Sikh Grammar School Rouse Hill (SSD-9472)
Request for Additional Information

I refer to Response to Submission (RTS) and Supplementary RTS for the Sikh Grammar School Rouse Hill (SSD-9472). After careful consideration, the Department is requesting that you provide the following additional information:

Sikh Grammar School

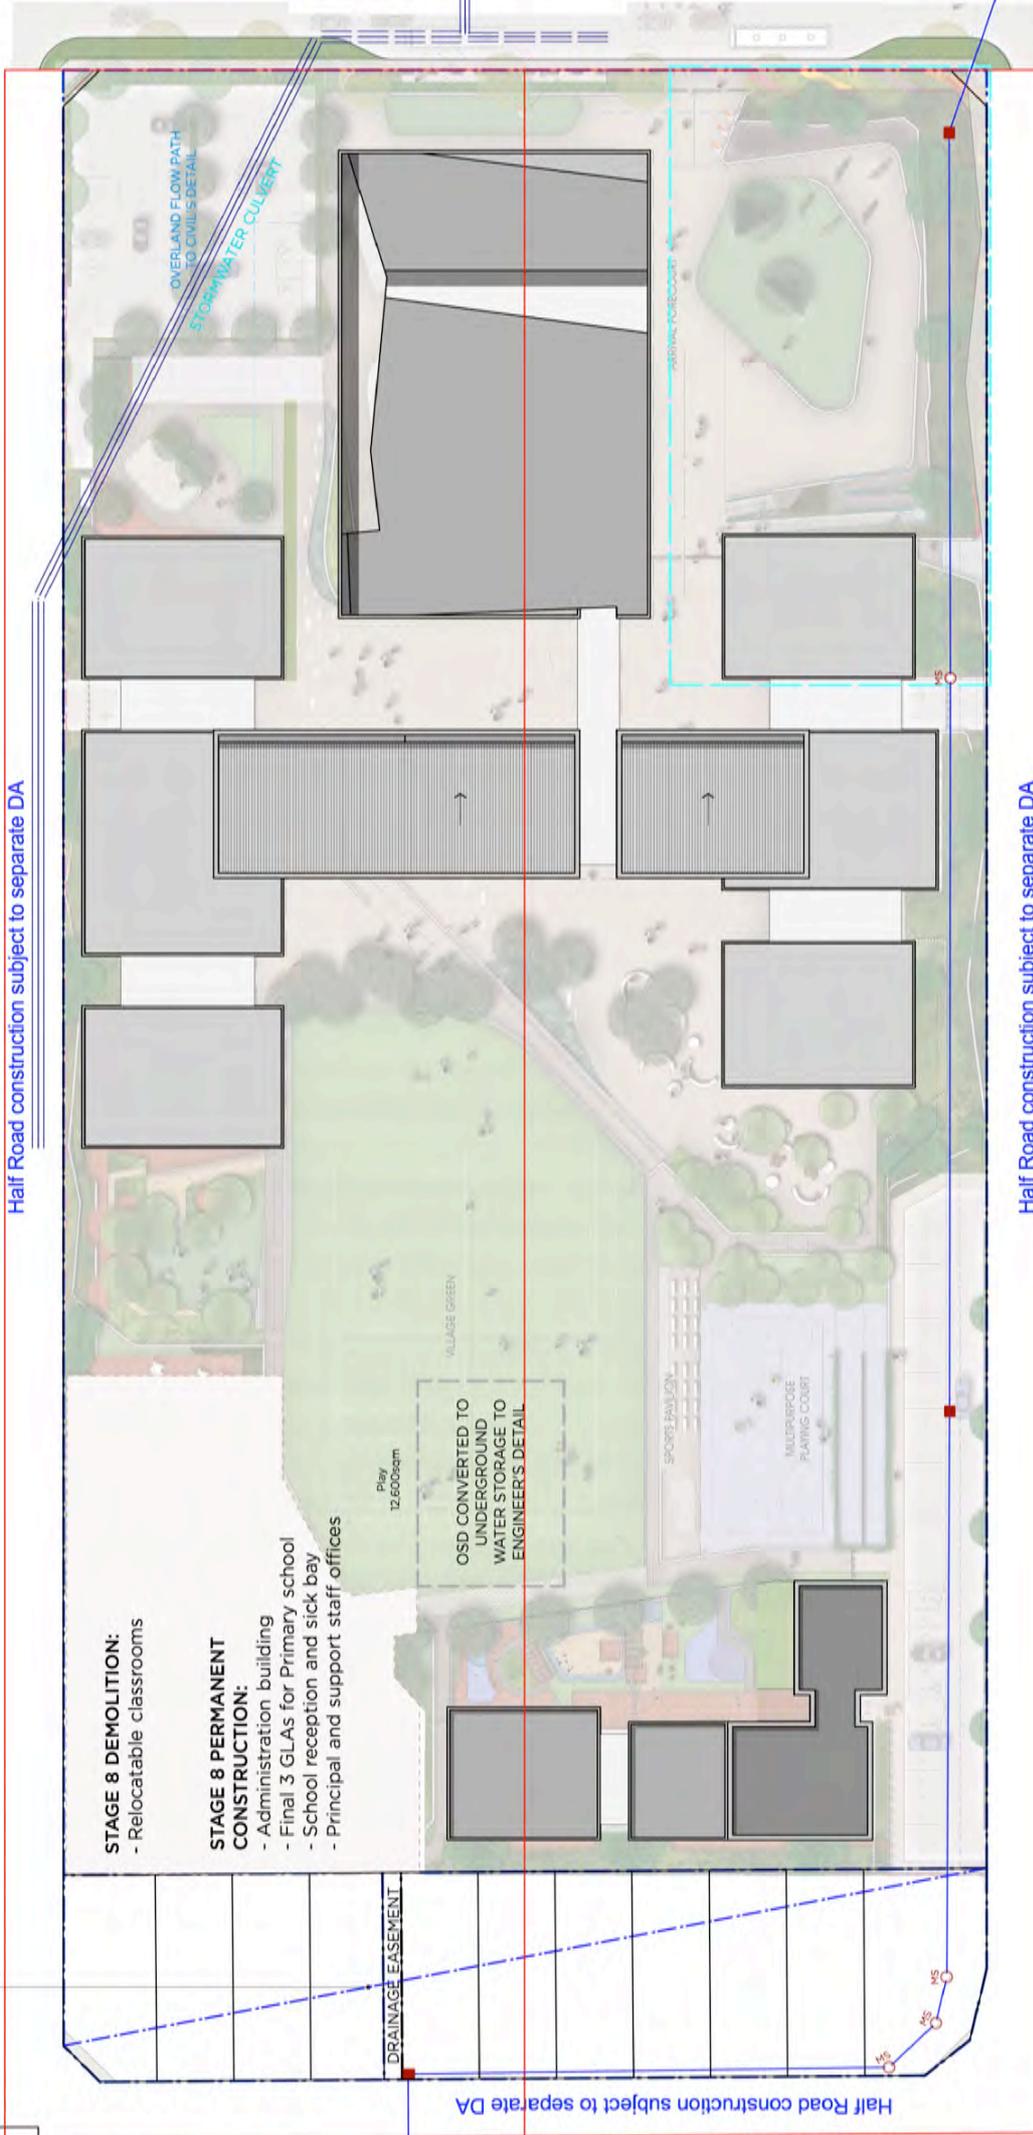
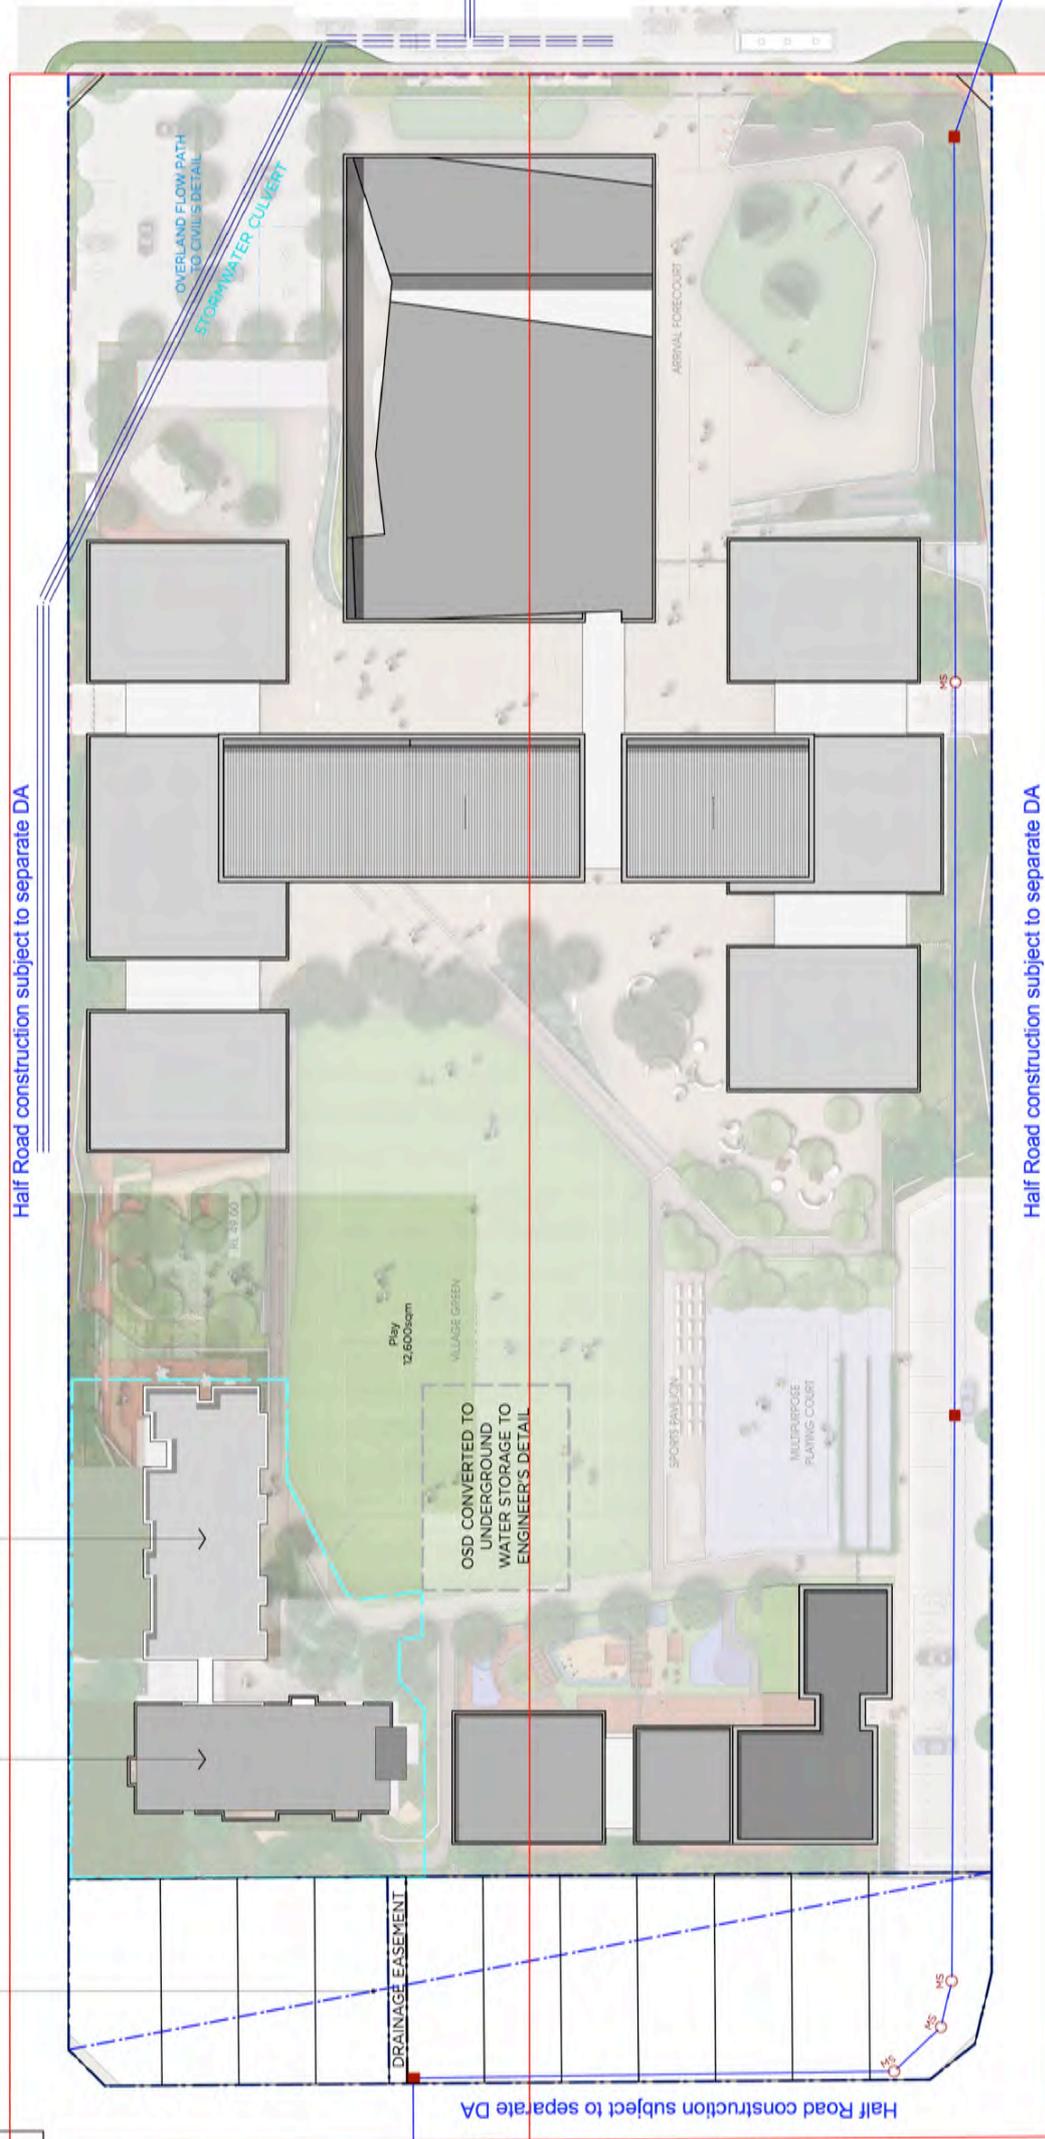
It is noted that throughout all the submitted documents (EIS report, RTS report and supplementary RTS) the construction timeframe is stated as 10 years. However, the staging plans in the Architectural Design Report (pages 59- 69 in Appendix 4 of the RTS) reflects 24-year timeframe. These staging plans are to be revised to reflect a 10-year construction timeframe so it's consistent with the submitted documents.
